Auburn Estates #6

April 15, 2005

RE: Application for Single Family Residences, Auburn Estates lots #6 and 9

Upon review of the site plans, the City's Planning Division has the following comments:

RIGHT ELEVATION

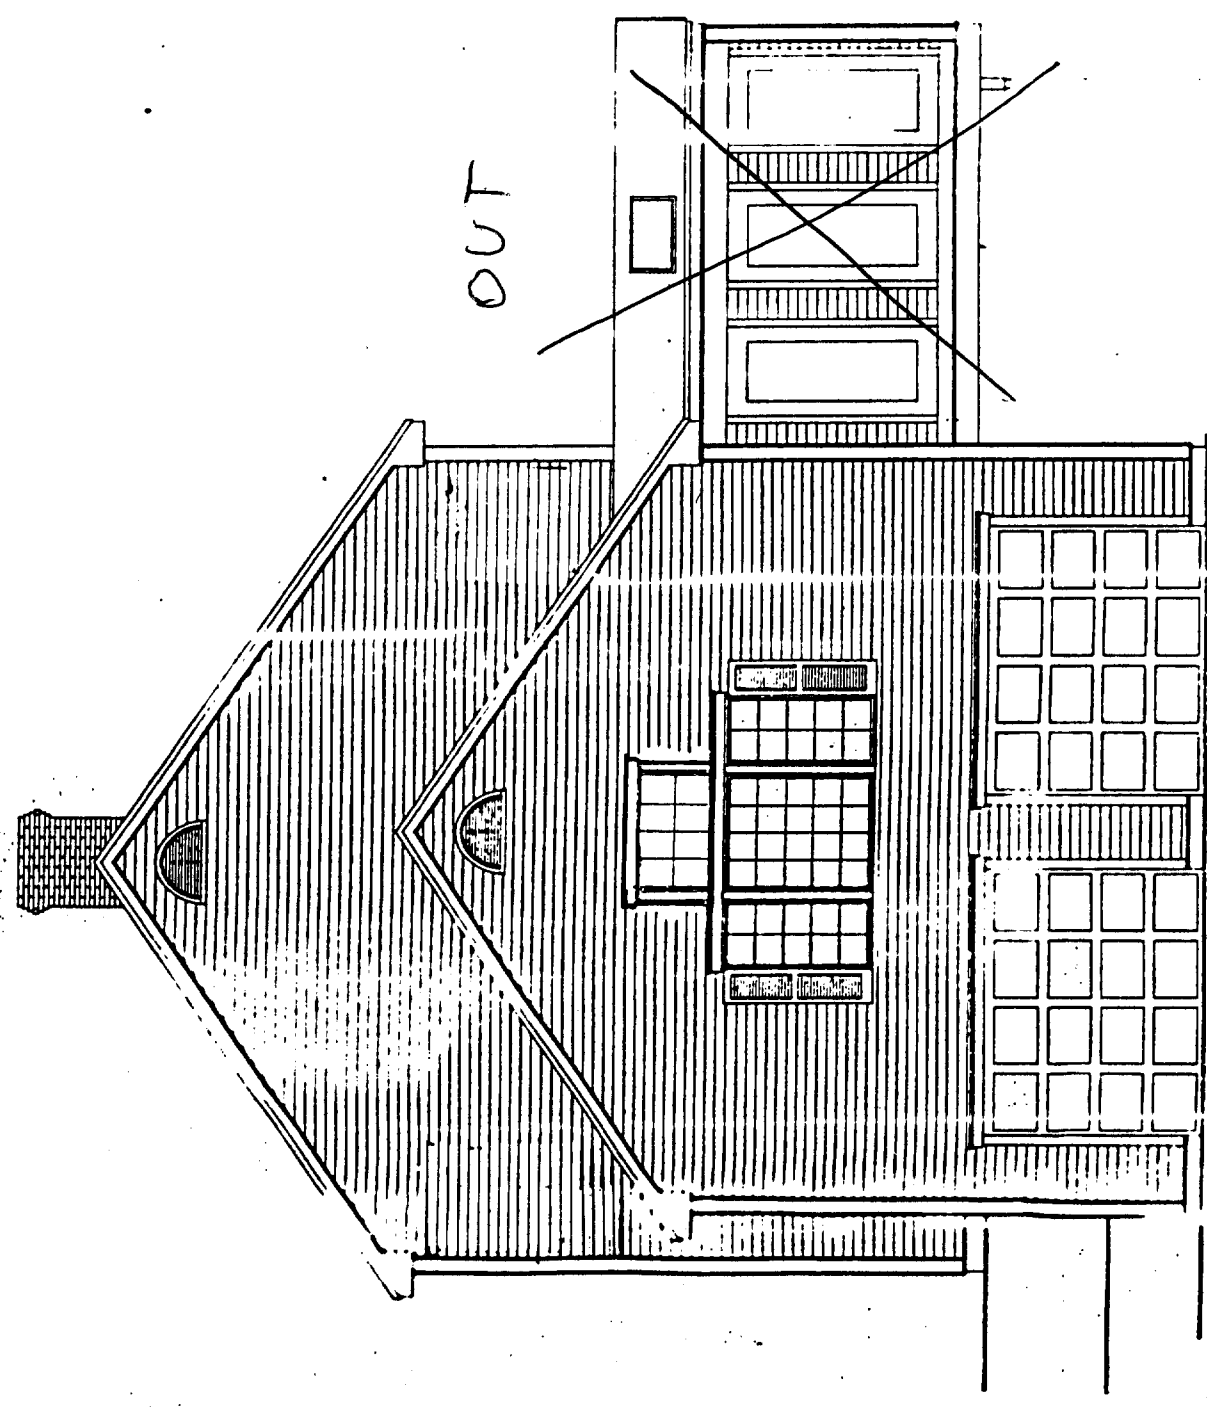
1. Please remove proposed grading/contours out of the tree-save area.
2. The daylight feature on the rear building elevation does not match your site plan.
3. Add a cleanout to the sewer lead (80' intervals from sewer main).
4. Move street tree so that it is not over the proposed utilities (right side of driveway is better). Also, add a 2<sup>nd</sup> street tree to this lot, perhaps along the right side of the driveway is a possible location.
5. Although the proposed grading is consistent with the approved subdivision, it would be better to direct drainage away from the building on lot 7. Please address.
6. Please add or note that any new retaining walls with 4' or greater of vertical drop requires some method of fencing/railing, per code.
